CITY OF ALBUQUERQUE

**Re: Sunport Property Utilities Grading and Drainage Plan, Tract 22 & 23
Engineer's Stamp Dated 6-7-2012 (M-14/D034)**

Based upon the information provided in your submittal dated 6-20-2012, the above referenced grading and drainage plan cannot be approved for Grading Permit until the following comments are addressed:

SUNPORT PROPERTY UTILITIES GRADING & DRAINAGE PLAN

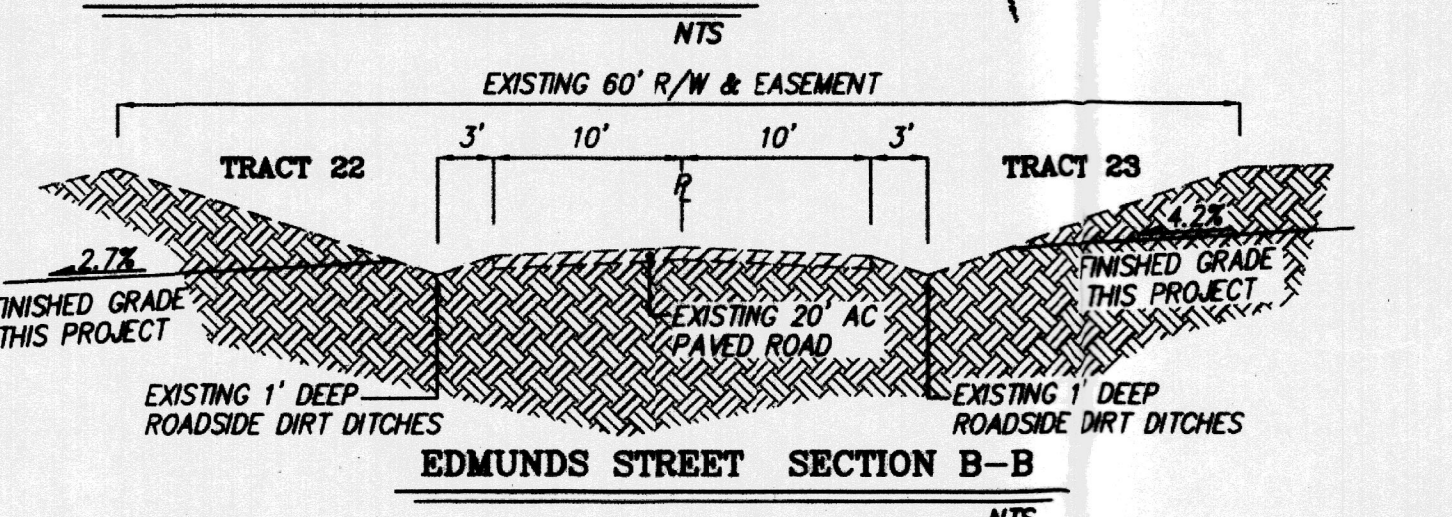
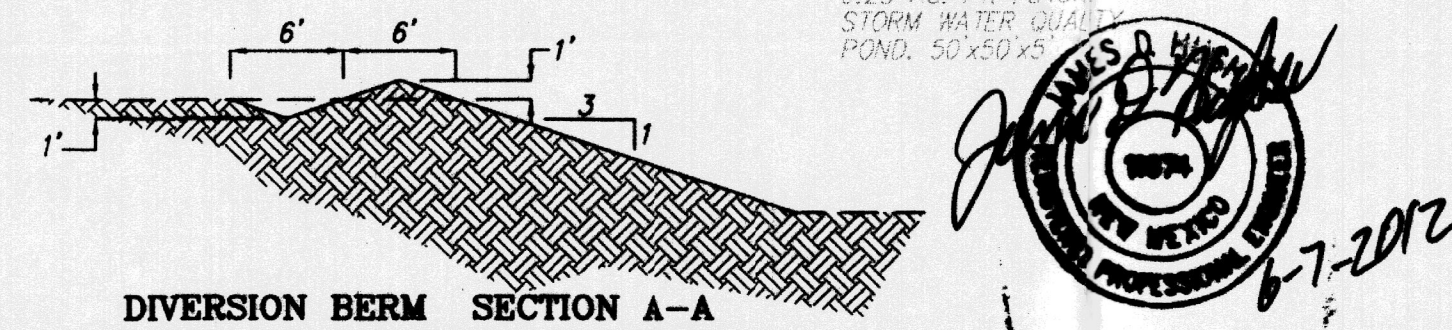
- AMAFCA approval is required for discharging into the Southern Diversion Channel.
- A floodplain permit must be obtained for grading to take place in Basins 105 and 108.
- Provide runoff calculations for each of the basins.
- It appears Basin 103 flows directly into 104 through a 36-inch CMP underneath Edmund Street and not around the basin to the north as stated in the plan.
- A street capacity analysis will be needed for Edmund Street to ensure flows are contained from Basins 106C and 106D.
- How are flows directed north along the western property edge to the Airport Arroyo Pond?
- Several A-A sections are noted on the plan, are these all supposed to be the same detail?
- Section B-B as well as many of the basin flows are not clearly visible on the plan.
- The effective floodplain date in the legend should read "9-26-2008".
